West Burton Solar Project

Land Plan Revision B – Change Application Version

Prepared by: Dalcour Maclaren
January 2024

PINS reference: EN010132
Document reference: CR1/WB2.2_B
APFP Regulation 5(2)(i)

Land Plans
 Sheet 6 of 10
 Revision A

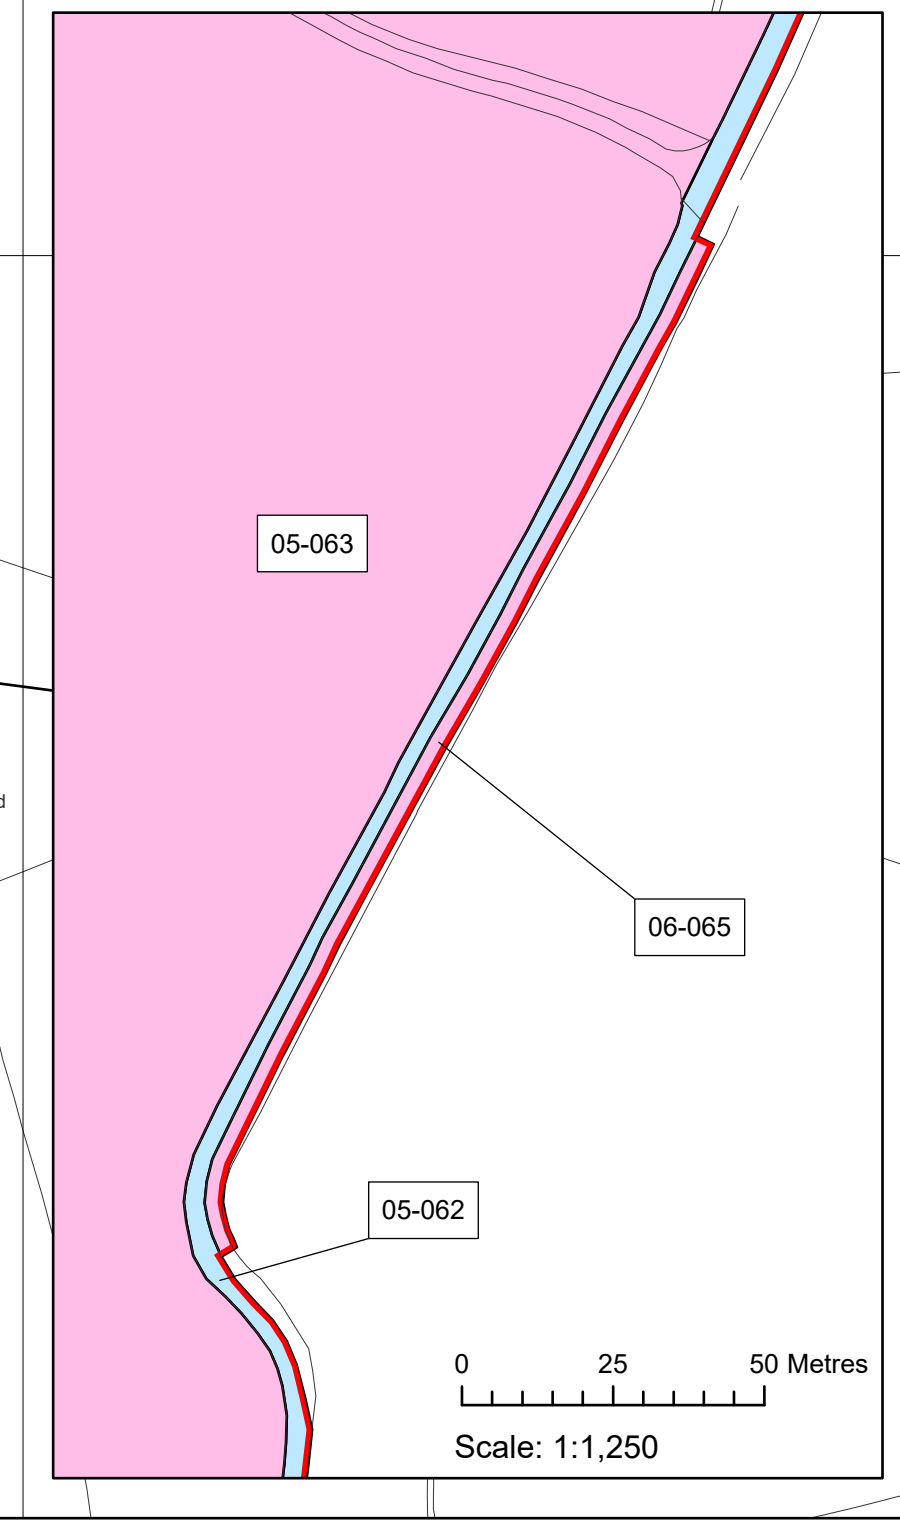
Sheet 6 of 10	10	New plots added	Changes in the Red Line Boundary have created plots 06-072a, 06-072b, 06-072c, 06-072d, 06-073a, 06-073b, 06-074a
Sheet 6 of 10	10	Update to the list of plots in the key on Sheet 6	Updated to reflect addition of new plots 06-072a, 06-072b, 06-072c, 06-072d, 06-073a, 06-073b, 06-074a
